RESPONSE TO SUBMISSIONS

Factory Extensions
Factory Extensions (Borg Panels & JeldWen, Oberon)
Lot 26 DP 1200697 and
Lot 2902 DP 1056754

April, 2015

Factory Extensions (Borg Panels Oberon)
Lot 26 DP 1200697 and Lot 2902 DP 1056754

Site Plan

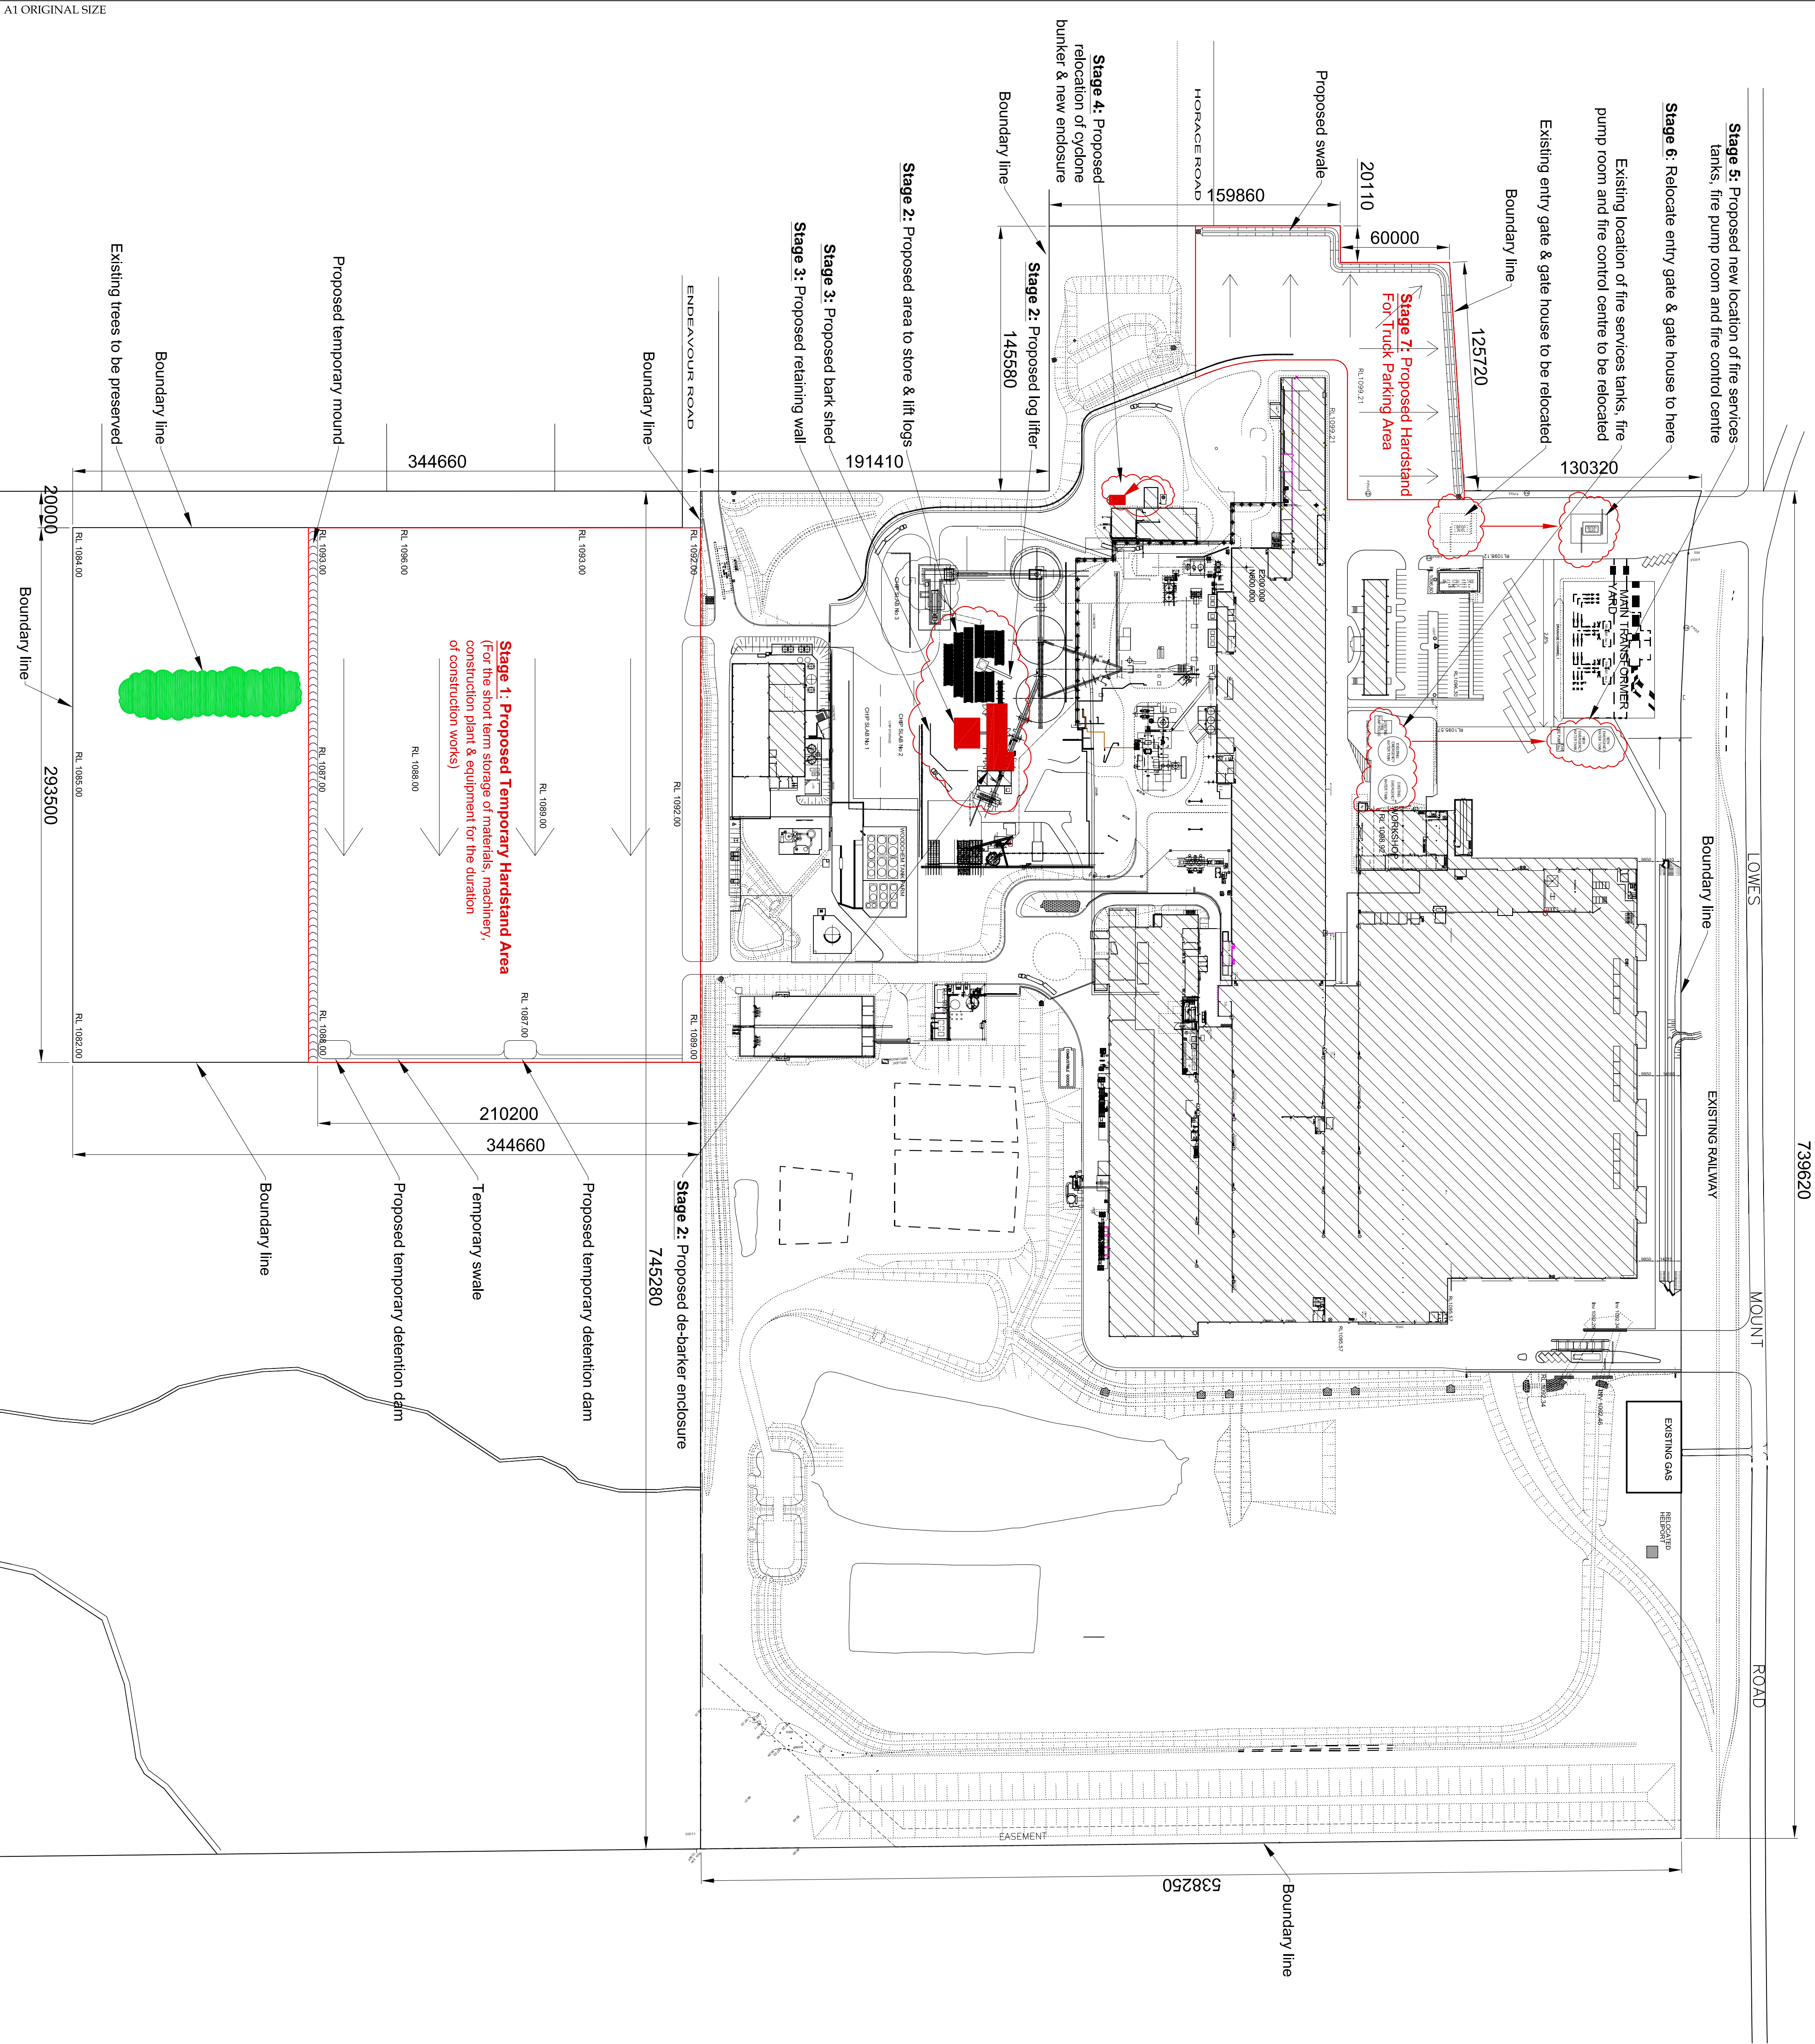
In relation to the permanent hardstand area clarification is requested on:

- whether the proposed swale is to connect to the existing sediment pond to the east of this area, and*
- whether any modifications are required to what appears to be an existing swale and associated stormwater management adjacent to the existing infrastructure on the north-eastern boundary of the area.*

The proposed open swale drain detailed in the application involves the relocation of the existing open swale drain (referred to as the north east boundary area by Office of Water) which currently drains to the existing sediment pond to the east. The new open swale drain will continue to drain to the existing sediment pond to the east.

Appendix B illustrates how this will be implemented.
